## **M54 to M6 Link Road**

**TR010054**

**8.16 Review of Woodland Mapping, Impact Assessment and  
Compensation**

<b>Regulation Number</b>	Regulation 5(2)(q)
<b>Planning Inspectorate Scheme Reference</b>	TR010054
<b>Application Document Reference</b>	8.16
<b>Author</b>	M54 to M6 Link Road Project Team and Highways England

Drawing file: TR010054 / TR010054-001020-TR010054 M54 6.3 Figure 2.7 Draft Masterplan Sheet 5 of 5.pdf

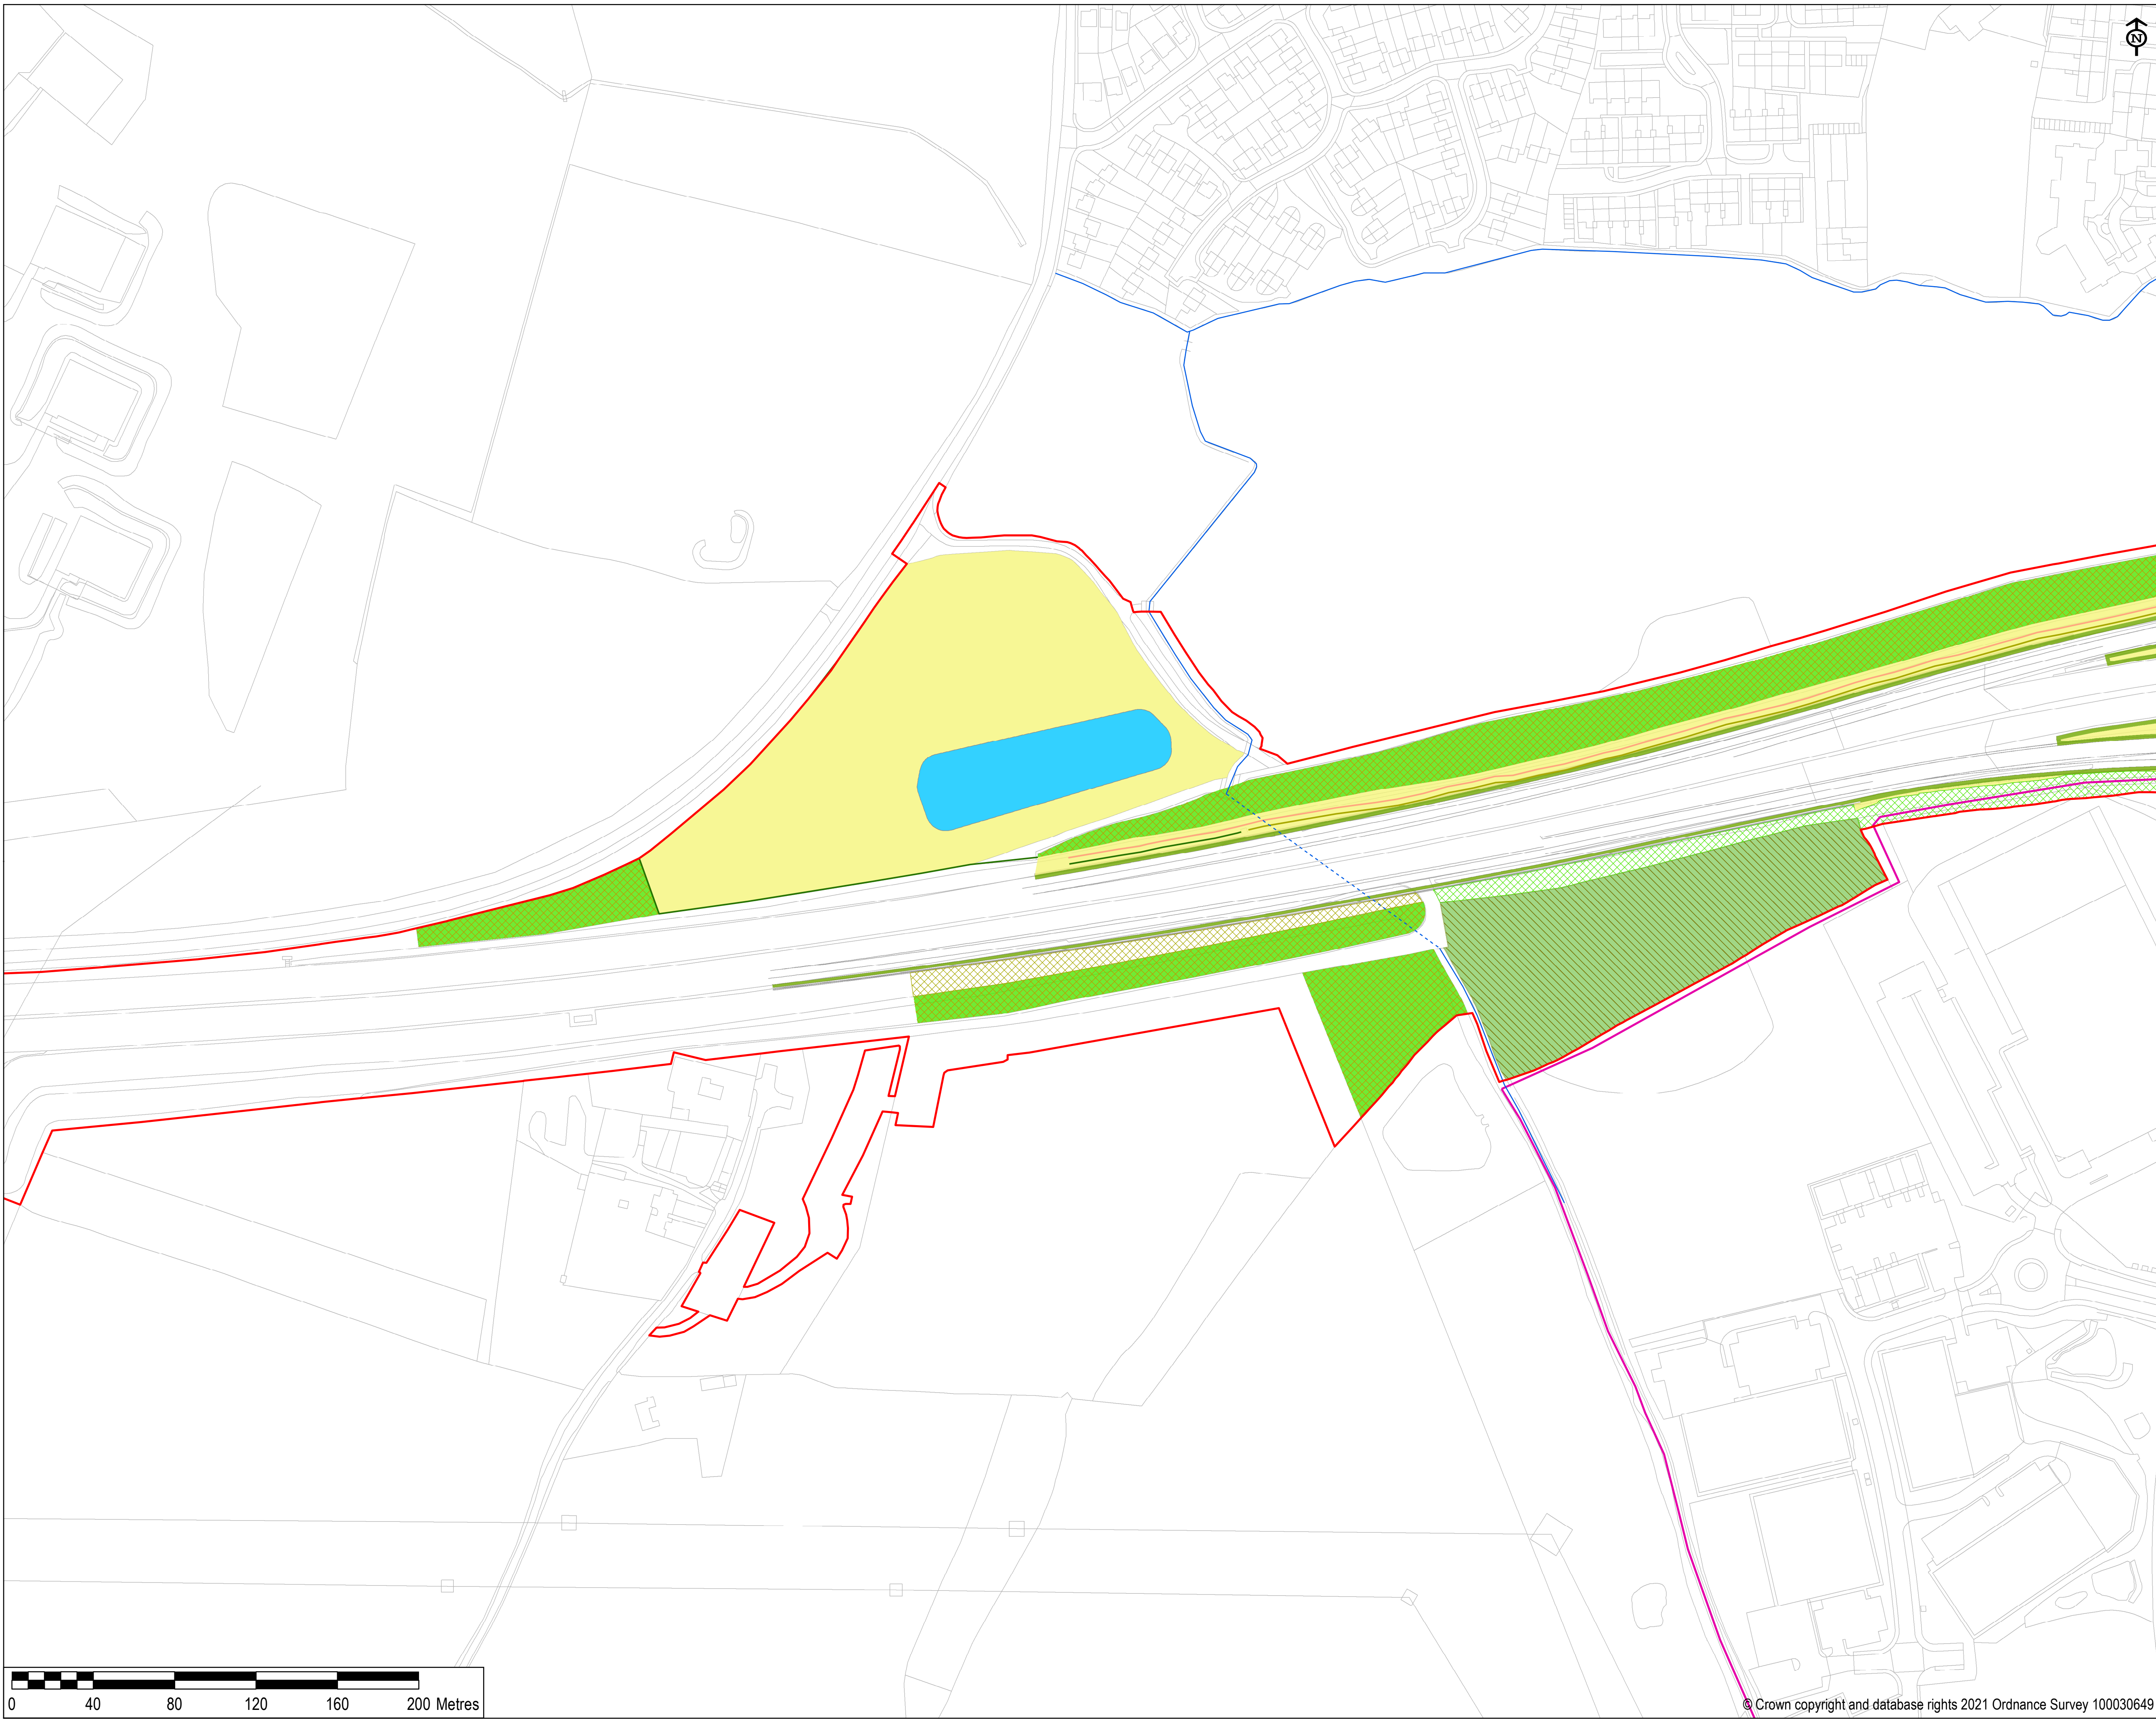
- 4.1.7 The Environmental Masterplan Figures 2.1 to 2.7 [AS-086 to AS-092/6.2] for the Scheme clearly sets out HE's approach to delivering essential mitigation across the extent of the Scheme, with features such as woodland, grassland, hedgerows and ponds proposed on several other parties' land, not just land owned by Allow.

- 4.2.1 The Scheme would result in the loss of 2.11 ha of woodland and 0.46 ha of standing water (pond) within Lower Pool LWS/SBI. Construction would take place within 5 m of an additional 0.47 ha of woodland within Lower Pool which could be damaged or lost. To compensate for this, a total of 4.84 ha of woodland, 0.57 ha of standing water and 0.78 ha of grassland is proposed to be created on Plot 5/2 (as shown in Plate 4), which is in the ownership of Allow. Although no grassland is lost within Lower Pool, the new grassland would form a buffer between the pond and the woodland, reducing the risk of significant build-up of organic material via leaf fall in the pond which can result in nutrient overload and loss of the pond ecosystem. The grassland would also reduce the negative effect of shading of the pond by the woodland and allow future safe access to the pond for management.

4.2.3 Whilst the new link road represents a partial barrier between woodland on the east and west sides, the compensatory woodland planting on Allow's land will be across the link road from the retained areas of Lower Pool. The new link road between Hilton Lane and the pool within Lower Pool will be in a cutting, which will facilitate crossing by birds and bats and minimise the risk of collision for those vulnerable to road traffic deaths such as barn owl. The habitat creation next to the highway will also physically connect the compensatory and the retained woodland via the vegetated Hilton Lane immediately adjacent to retained woodland. In addition, the compensatory woodland will connect to existing woodland to the southwest. A mammal tunnel will allow safe crossing there. The potential to provide new woodland planting and replacement standing water to the east of the mainline of the Scheme was explored during the development of the landscape design at the request of Allow. However, due to the presence of the designed landscape of Hilton Park and the Shrubbery, which is a feature of the historic parkland, on the eastern side of the Scheme any additional woodland planting would result in adverse effects on these receptors. The parkland also forms the setting of the Grade I Hilton Hall and associated buildings. The potential to locate planting to the east was discussed with Historic England at a meeting on the 13 August 2019. It was agreed that the form of features within the retained historic park such as the historic boundary of Lower Pool/ The Shrubbery should be retained and that the woodland should not be extended into the remaining open parkland.

4.2.4 Plot 5/2 will compensate for the impacts to Lower Pool by providing new planting at a ratio of around 2:1 to that being lost. As stated above, there is no scientific basis for determining ratios for compensation. In this instance, the area of new planting is appropriate (i.e. twice as much as is being lost) given that the woodland being lost is within a LWS and supports protected species such as bats. There are always risks associated with creating new habitats, such as the suitability of the compensation site and the failure of new plants to establish, and these risks have been factored into the compensation proposals.

4.2.5 It should be noted that the revised mapping exercise undertaken by HE has not changed the quantum of compensation proposed on plot 5/2. The revised mapping did not alter the area of woodland lost within Lower Pool, and it is that which influences the proposals on plot 5/2. Changes to the amount of woodland lost in areas distant to Lower Pool, such as along the carriageways of the M54, do not impact on or affect the area of compensatory planting necessary at Lower Pool.

addresses the impacts to another LWS, Brookfield Farm, or has a multitude of functions including landscape integration, visual screening and biodiversity. Any changes in the areas of woodland to be lost have therefore not resulted in any changes in the Environmental Masterplan. Integrating the new road layout into the wider landscape is not based on the existing areas of woodland to be lost. The scale of the impact to Brookfield Farm LWS/SBI, which influences the amount of woodland planting in the north of the Scheme distant to plot 5/2, has not changed.
